Medworth Energy from Waste Combined Heat and Power Facility

PINS ref. EN010110
Document Reference: 10.4
Revision: 1.0
Deadline: 2
March 2023

Applicant's Response to NCC and KLWN's Local Impact Report

- Notes:
1. Proposed visibility based on New Bridge Lane being subject to a revised 30mph speed limit.
  2. New street lighting has been provided on an indicative basis (at 30m intervals and at conflict areas) and will require detailed design and assessment.

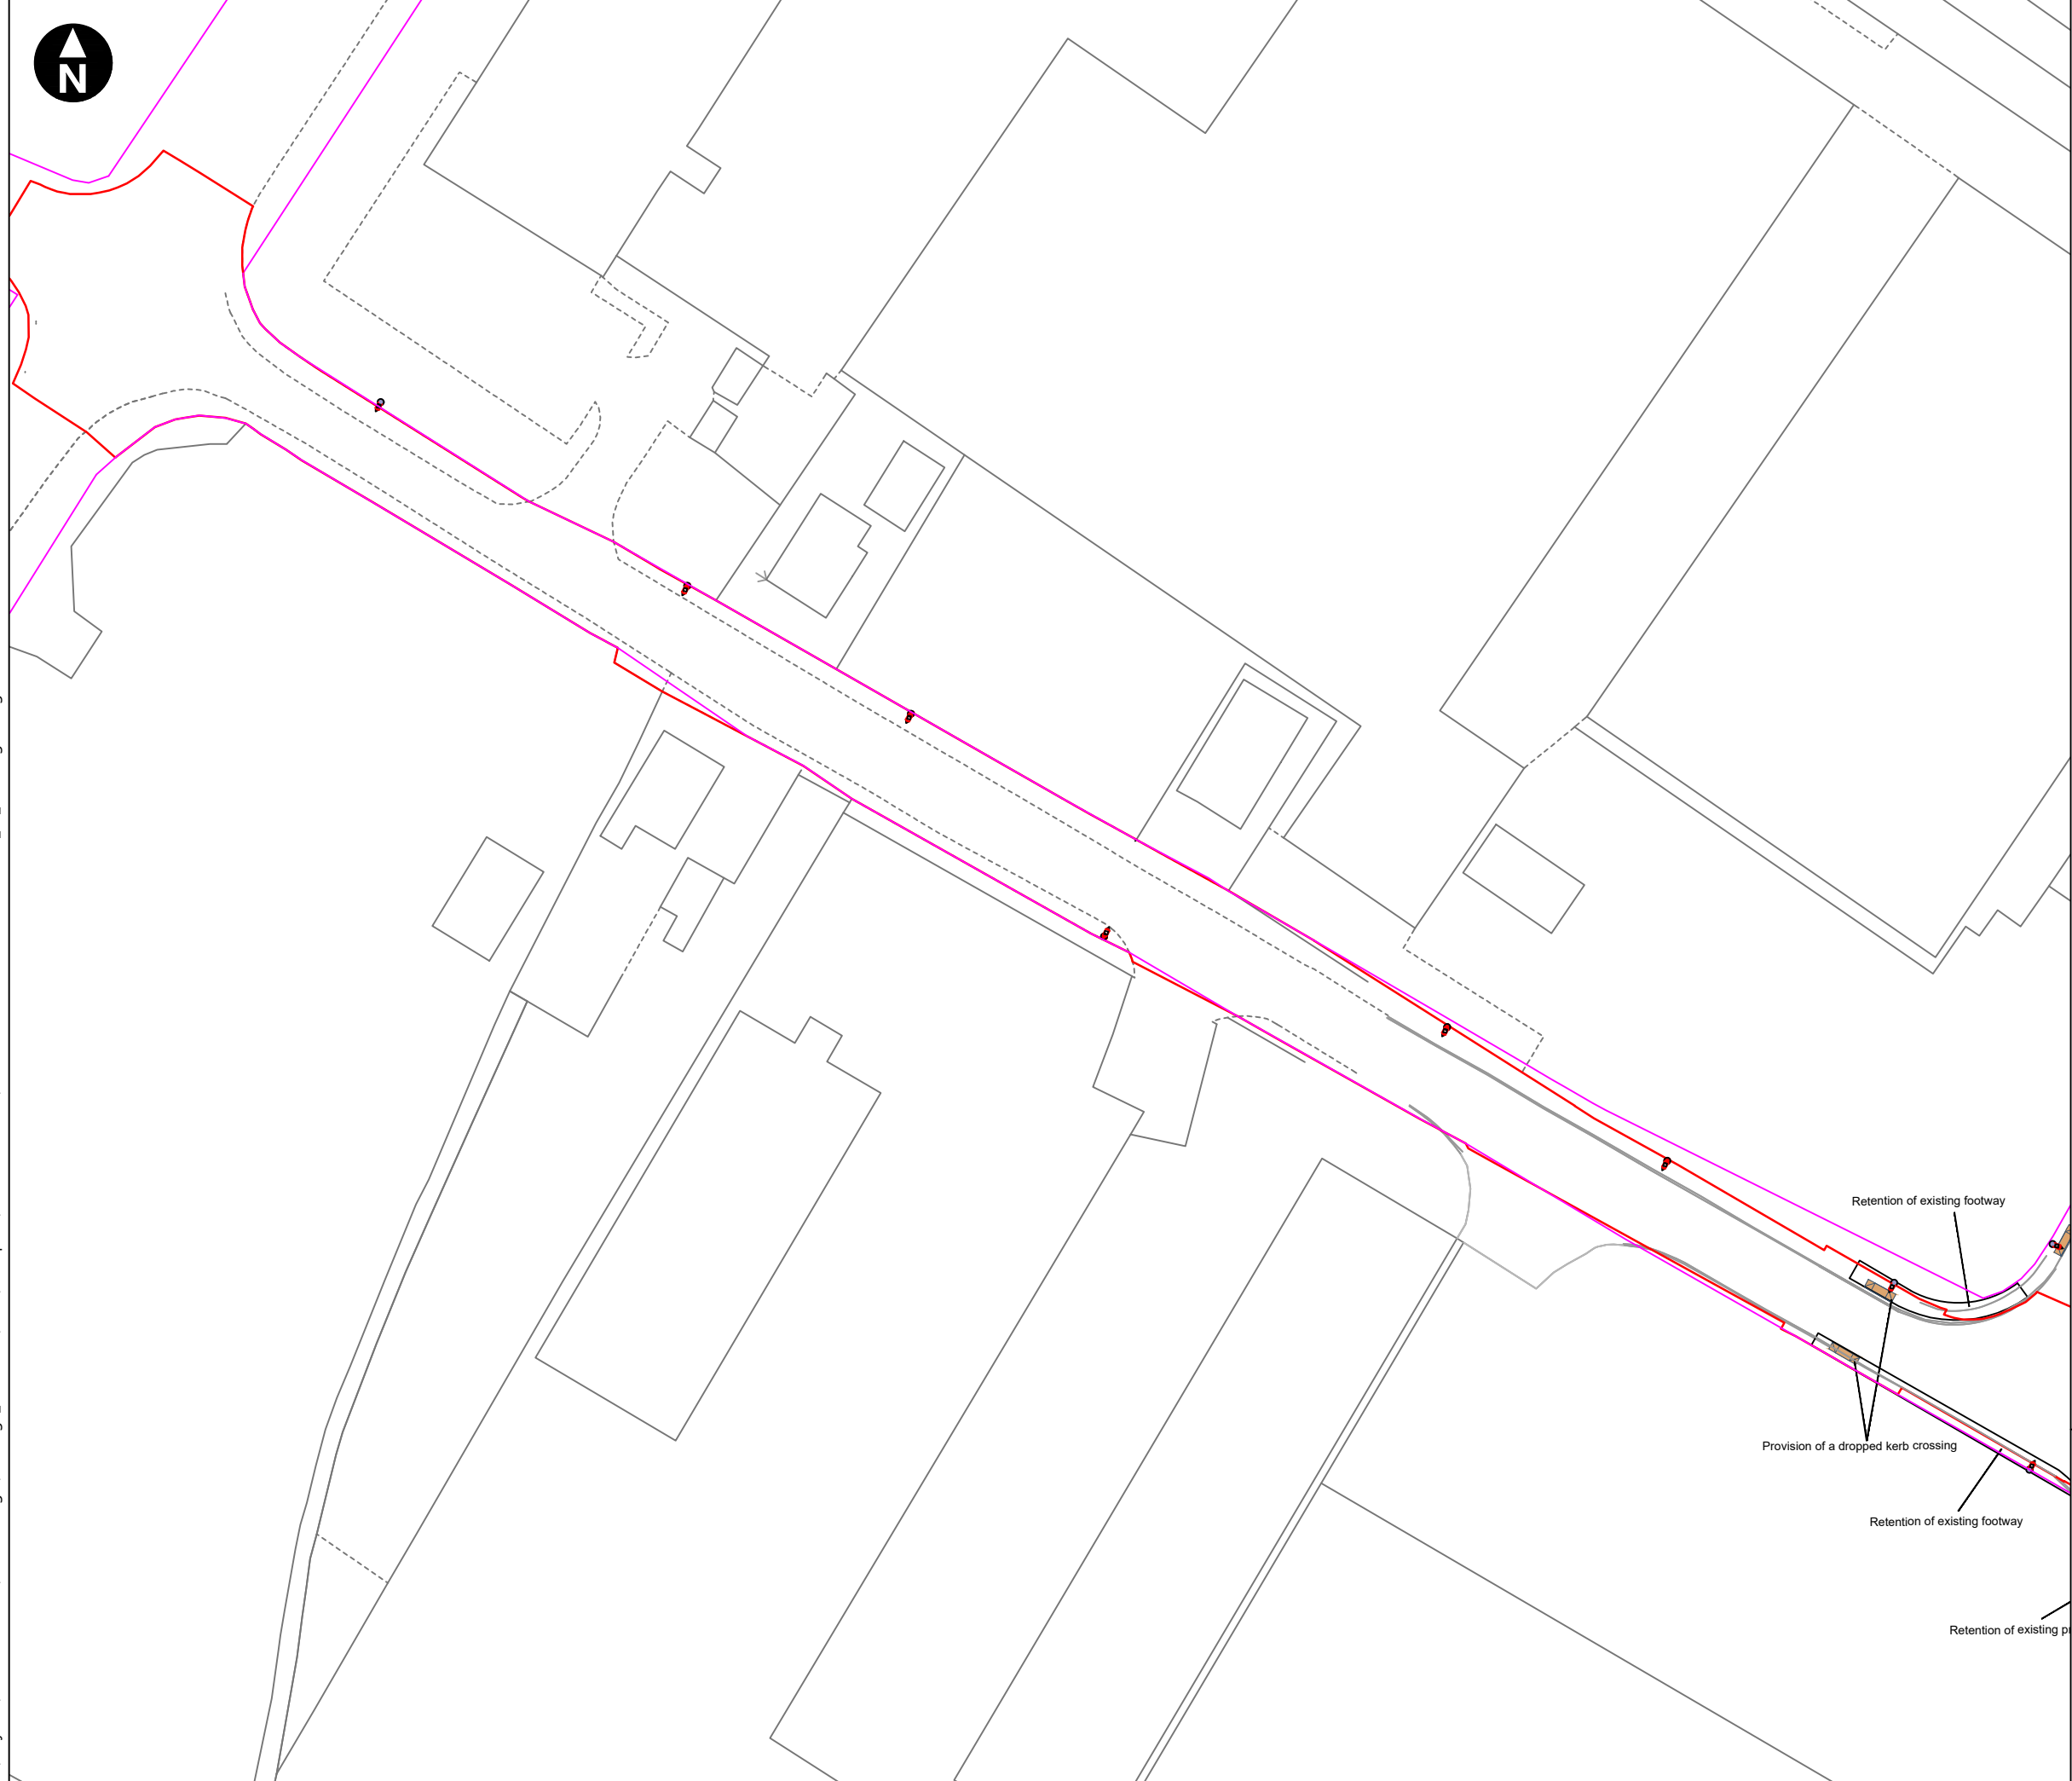
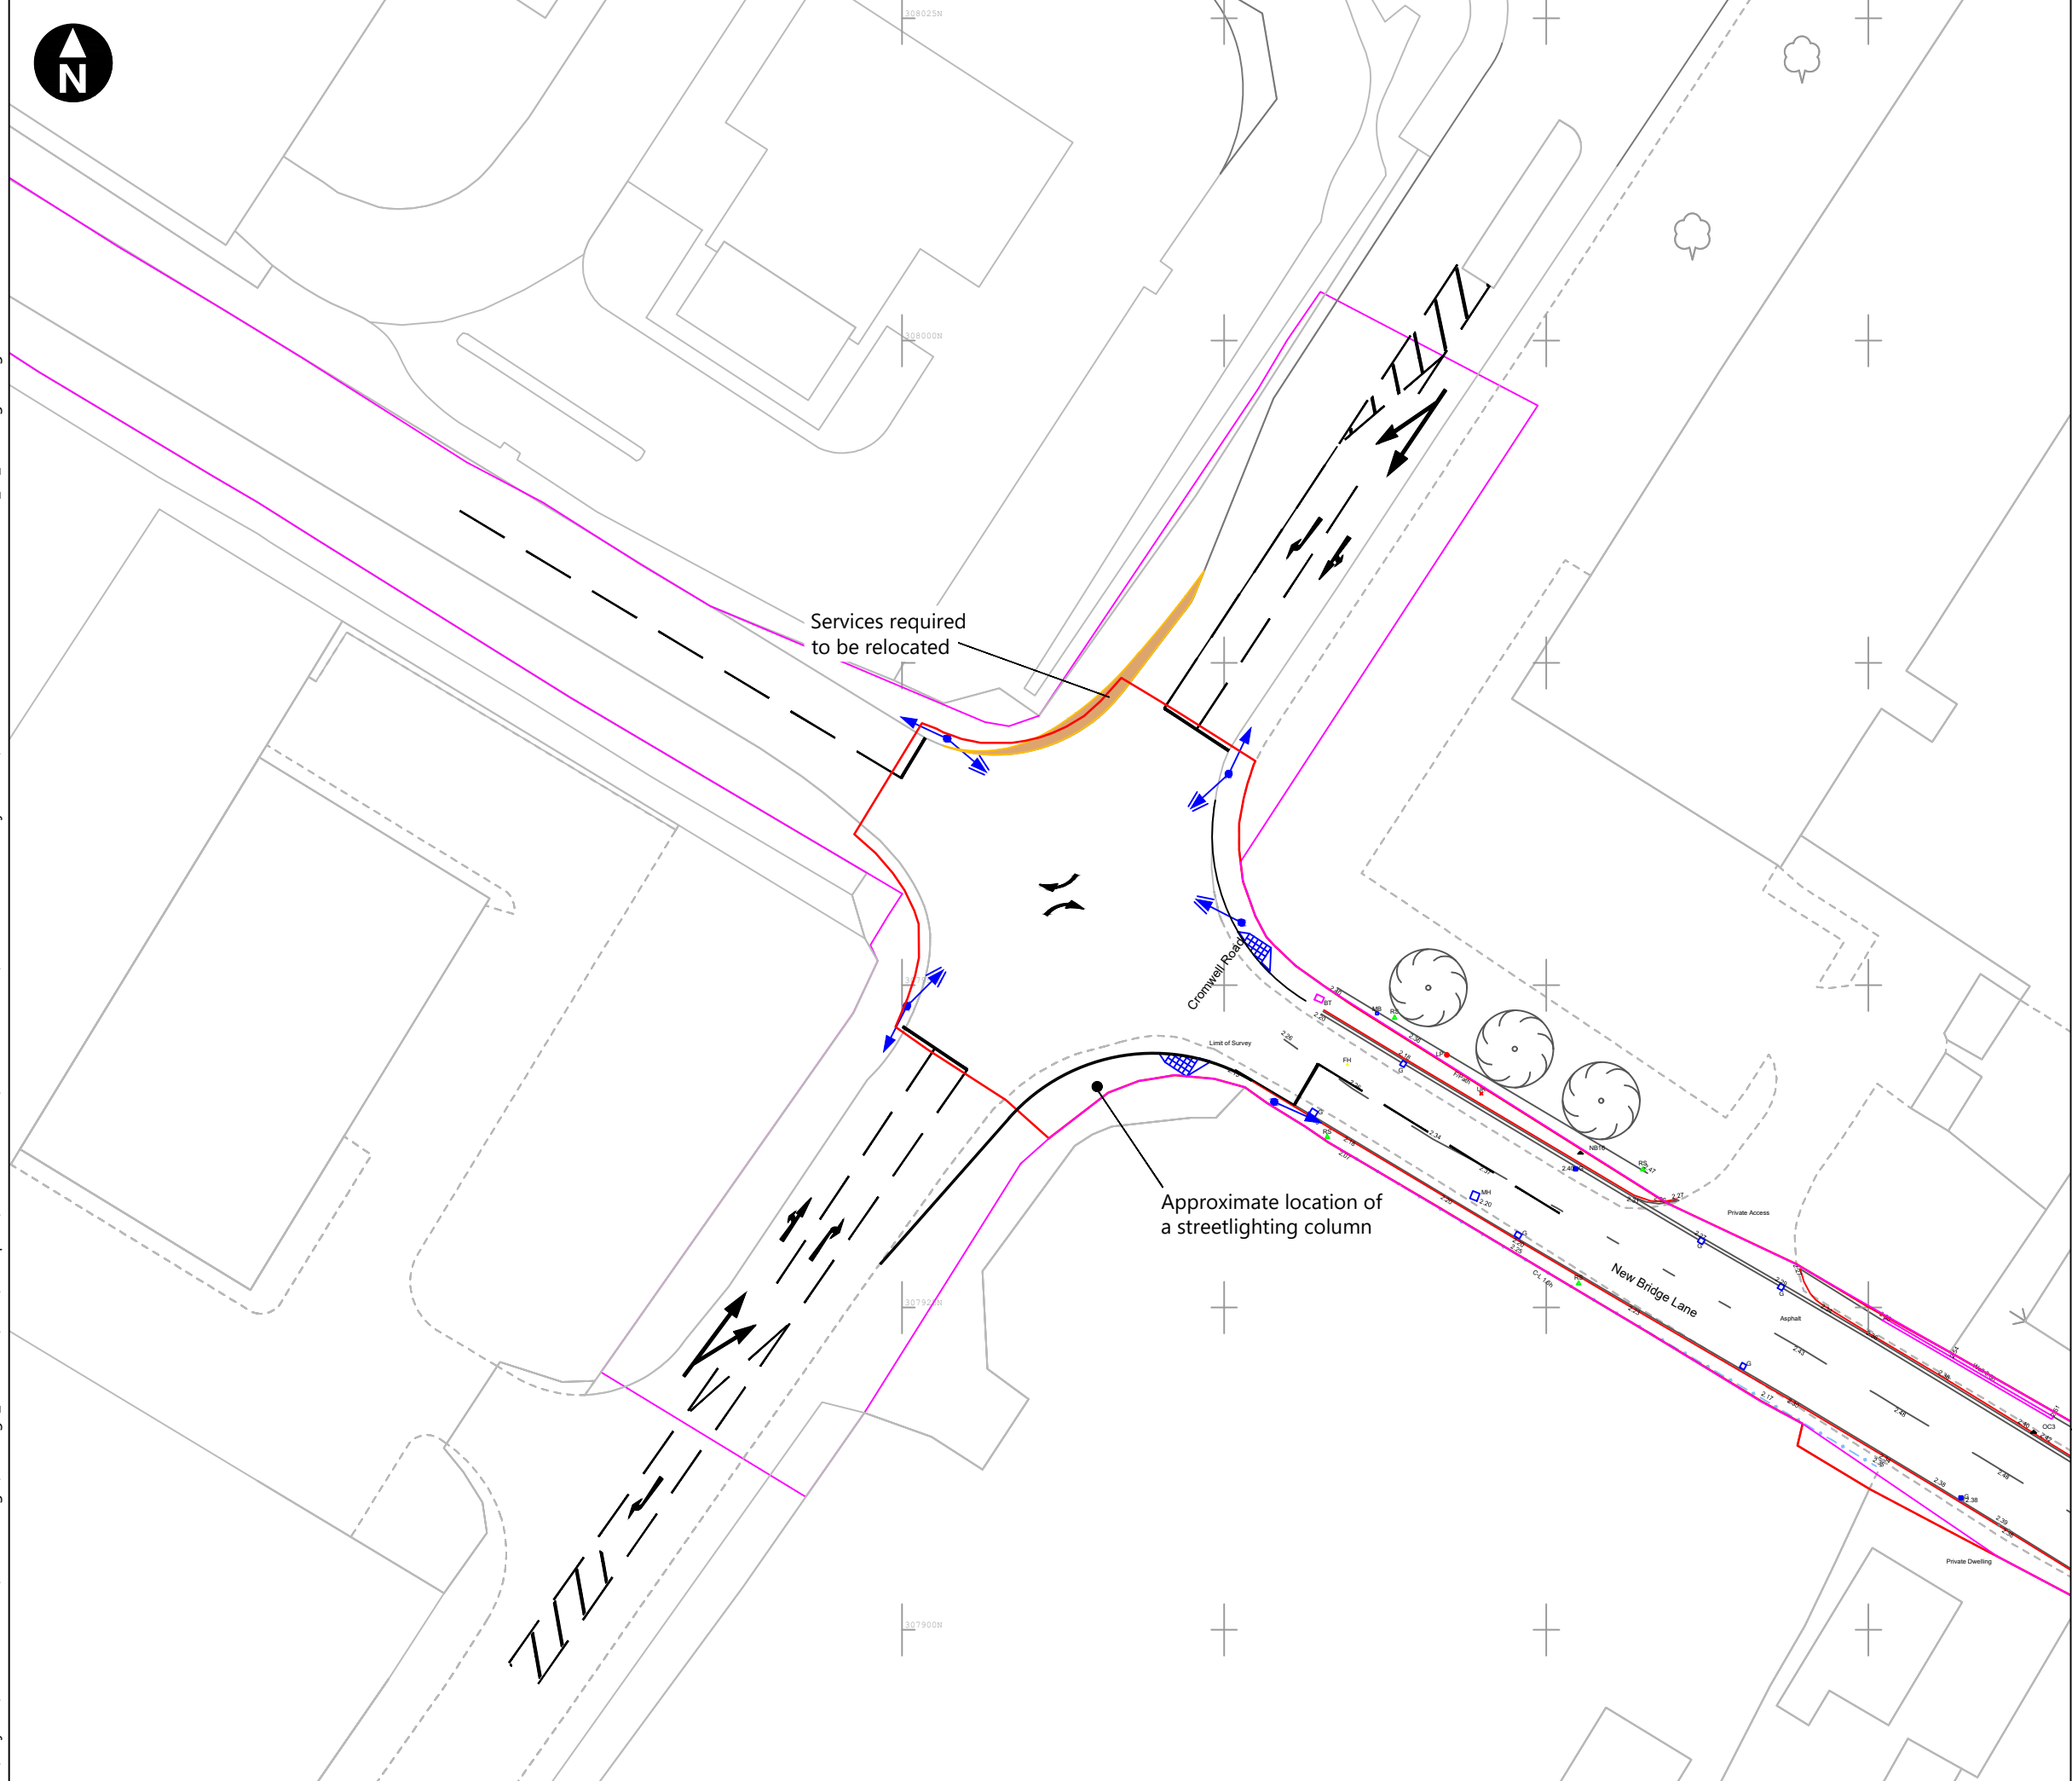
8.15	Requiring the new access route via the Cromwell Road link as early as possible would greatly reduce the impact on West Norfolk as the route is almost completely through commercial land, passing approximately four dwellings. This would be welcomed as a condition.	<p>The impact on West Norfolk Receptors from vehicle noise related to the development is assessed in Table 7.15 of ES Chapter 7 Noise and Vibration (Volume 6.2) [APP-034]. All roads with KLWN residents adjacent are subject to negligible increases in traffic noise. Haul routes avoid low flow roads in west Norfolk and specifically avoid the A1101 Elm High Road/Churchill Road corridor.</p> <p>Construction HGV routing is controlled via ES Chapter 6 Traffic and Transport Appendix 6A Outline Construction Traffic Management Plan (Volume 7.15) [REP1-011]. The management plan is secured by Draft DCO (Volume 3.1) [REP1-007] Requirement 11.</p>

LIR Paragraph	Summary of NCC and KLWN's Comments	Applicant's response
		<p>The Applicant will access the EFW CHP Facility Site from New Bridge Lane as soon as the construction works necessary to implement it are completed. ES Chapter 3 Description of the Proposed Development (Volume 6.2) [APP-030] provides the construction programme as Graphic 3.23 Construction Programme Summary. This shows the Access Improvement works starting in Month 2 and completing in Month 7.</p>
